# Norfolk Vanguard Offshore Wind Farm

# Documents Errata

Applicant: Norfolk Vanguard Ltd  
Document Reference: Pre-ExA; Errata; 9.4

Date: December 2018  
Author: Royal HaskoningDHV

Figure: 1
 Viewpoint CH1: Church of St. Andrew, Bradenham

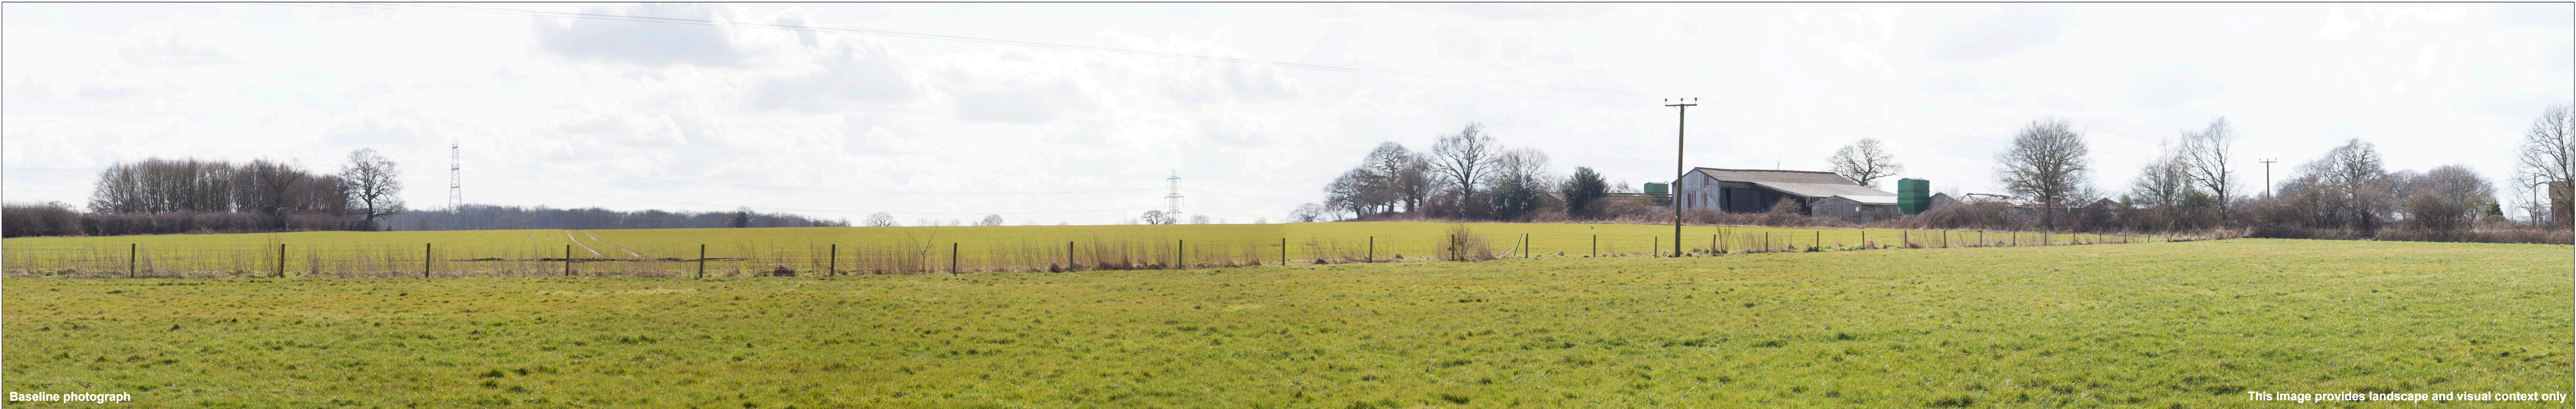
14. The submitted assessment of Cultural Heritage Viewpoint No. 1 (CH1) identified a small corner section of the proposed Norfolk Boreas substation as being visible in the photomontage view (seen at a distance of c. 1.6 km) from the northern most area of the grounds of the Church of St Andrew, Bradenham (34); a matter which was noted would be subject to consideration separately as part of the Norfolk Boreas assessment (approximately one year behind Norfolk Vanguard's development timeline).

15. However, following further analysis of the visualisations prepared for CH1, as part of the Norfolk Boreas assessment, it has become apparent that the project infrastructure visible (albeit to a minimal perceptibility) within the photomontage comprises a combination of both the Norfolk Boreas and Norfolk Vanguard onshore project substations, and therefore requires consideration as part of the overall application for Norfolk Vanguard.

18. Viewpoint CH1 (see Appendix 28.7) shows a very small section (glimpsed 'roof-top') of the proposed Norfolk Vanguard substation and a number of masts visible in the photomontage view (in the approximate centre of the Norfolk Vanguard substation extent indicated on the CH1 visualisation as seen at a distance of c. 1.6 km) from the grounds of the Church of St Andrew, Bradenham (34).

20. From a heritage perspective, the very slight visibility of the onshore project substation from the grounds of the Church of St Andrew is not considered to constitute harm to the heritage significance of the church nor represent any associated loss of appreciation of the heritage assets significance. This indirect (non-physical) impact is therefore considered to represent a negligible magnitude of effect upon the heritage setting of the church, resulting in a **minor adverse** impact significance as a worst case scenario. No additional mitigation is proposed.

23. The Church of St Andrew, Bradenham (34), may be subject to an impact of minor adverse significance. The very slight visibility of the onshore project substation from the grounds of the Church of St Andrew is not considered to constitute harm to the heritage significance of the church nor represent any associated loss of appreciation of the heritage assets significance and no further action and no further mitigation is considered to be required.
